Consultation Response from: KC Environmental Health (Pollution & Noise Control)		
2021/93547 - Icuk Technologies, 110-112, Lockwood Road, Lockwood, Huddersfield, HD1 3QX		
Change of use to form no. 2 hot food takeaways (Sui Generis) at ground floor with ancillary office and store at first floor and sub division of first floor apartment to form no. 3 dwellings (C3)		
Responding Date: 10 May 2022	Responding Officer: Mohammed Nasim	Responding Ref: WK202211778
<u>Comments</u> Note – These comments are supplementary to those made dated 01 December 2021. The applicant has submitted a Noise Impact Assessment authored by Environmental Noise Solutions dated 29 March 2022 Ref. NIA/10167/22/10267/v1/Lockwood Road. The objectives of the noise impact assessment were to: • Determine external noise levels at the application site • Assess the potential impact of the external noise climate on the proposed development with reference to relevant guidelines • Assess the potential noise impact at the nearest Noise Sensitive Receptors (NSRs) associated with the proposed development • Provide recommendations for a scheme of sound attenuation works, as necessary. A noise survey was undertaken on Wednesday

Title: PROPOSED FLOOR PLANS

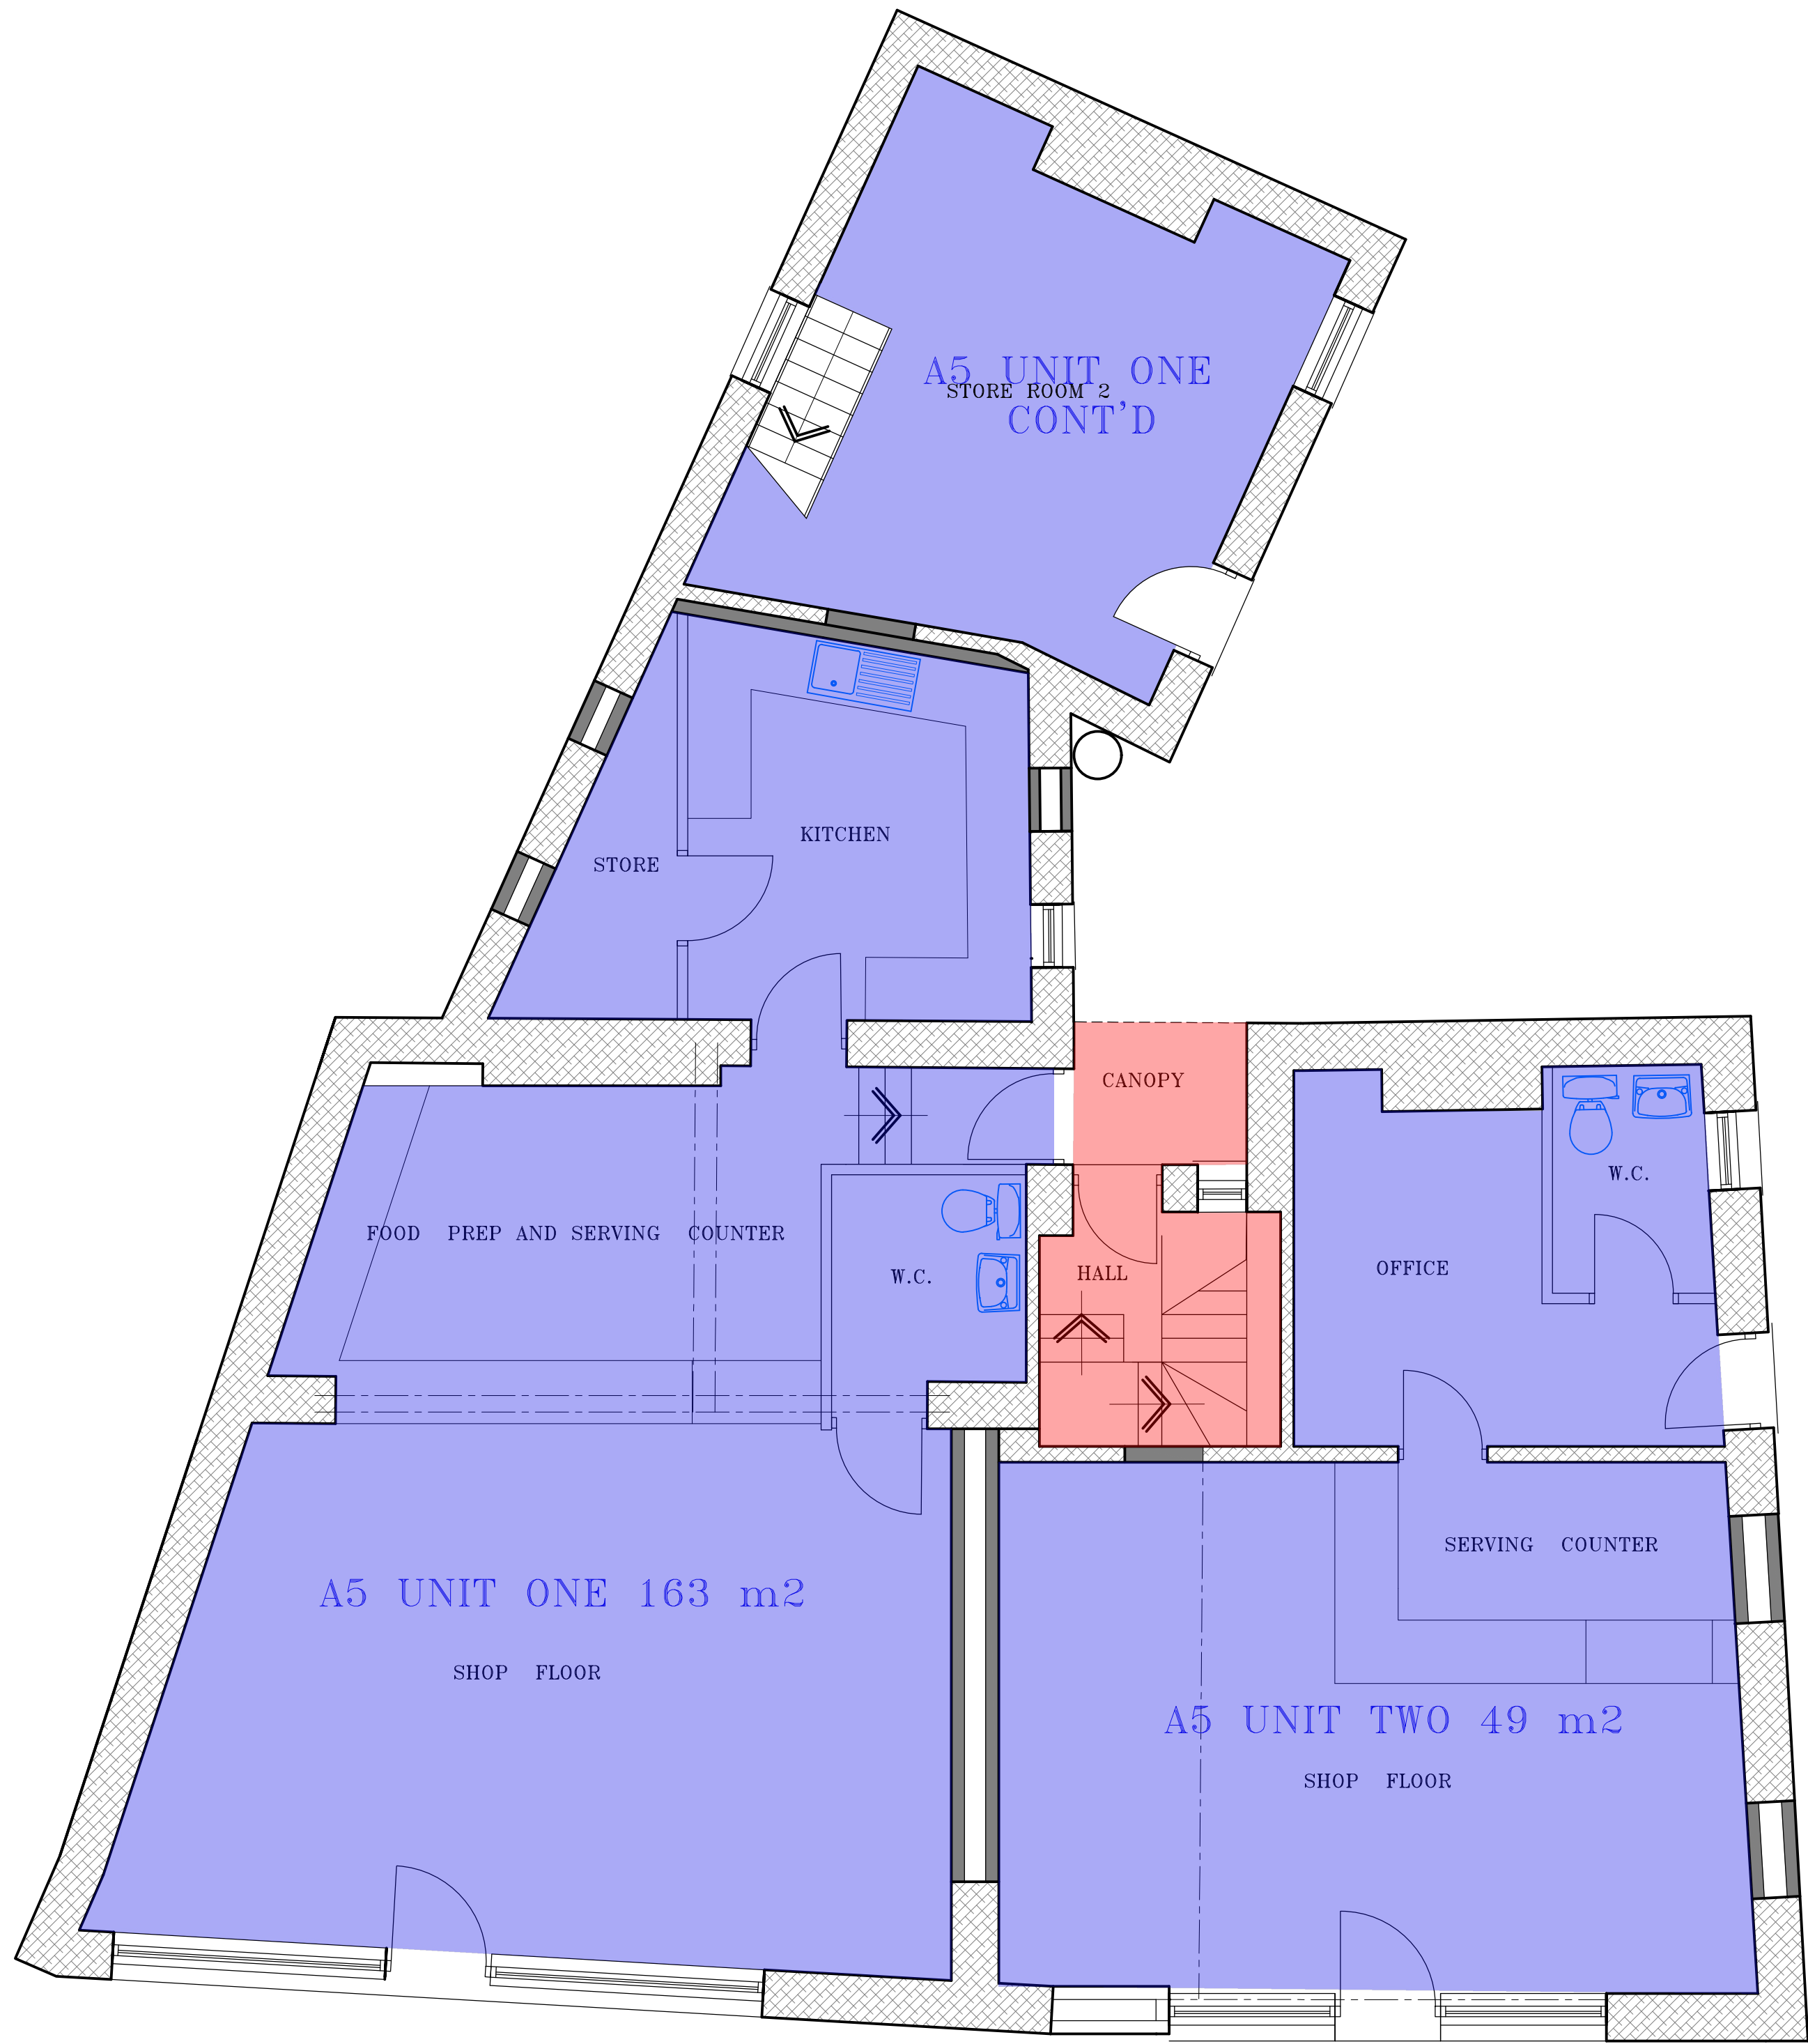
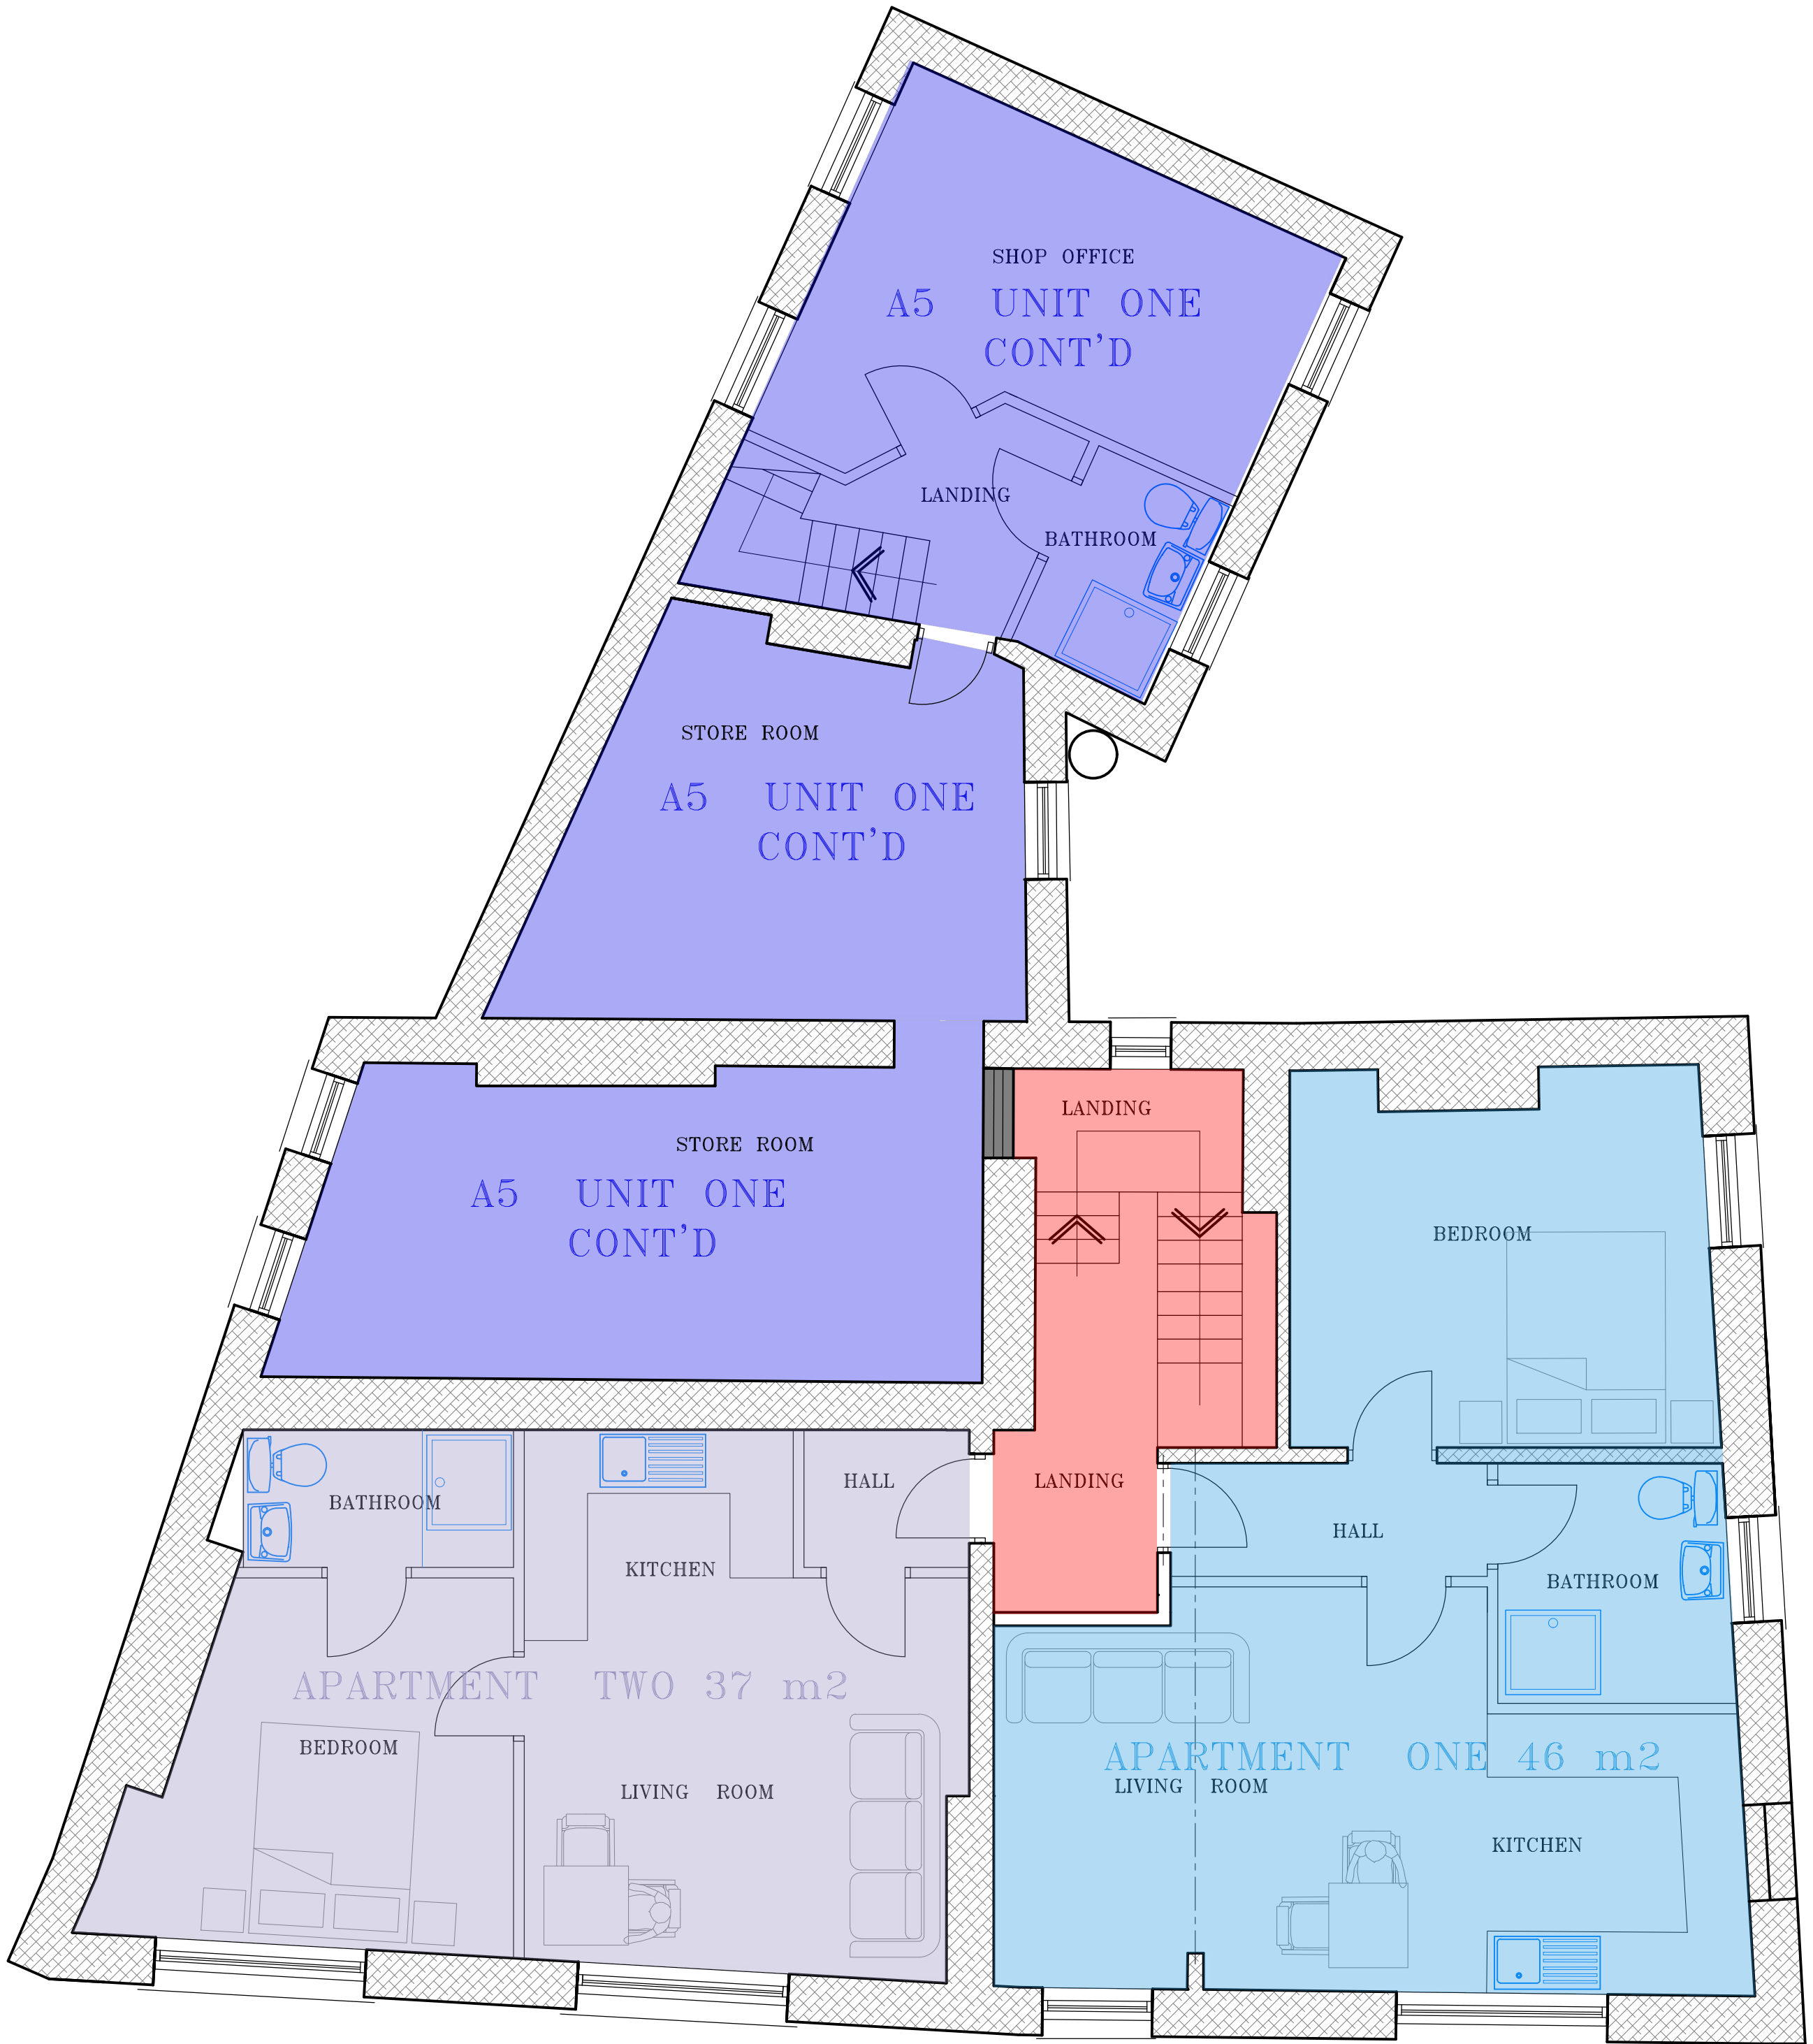
Para 5.14 looks at the sound insulation between the proposed ground floor takeaways and the first-floor accommodation and this meets with the higher standard specified within the West Yorkshire Planning Consultation Guidance and is therefore accepted.
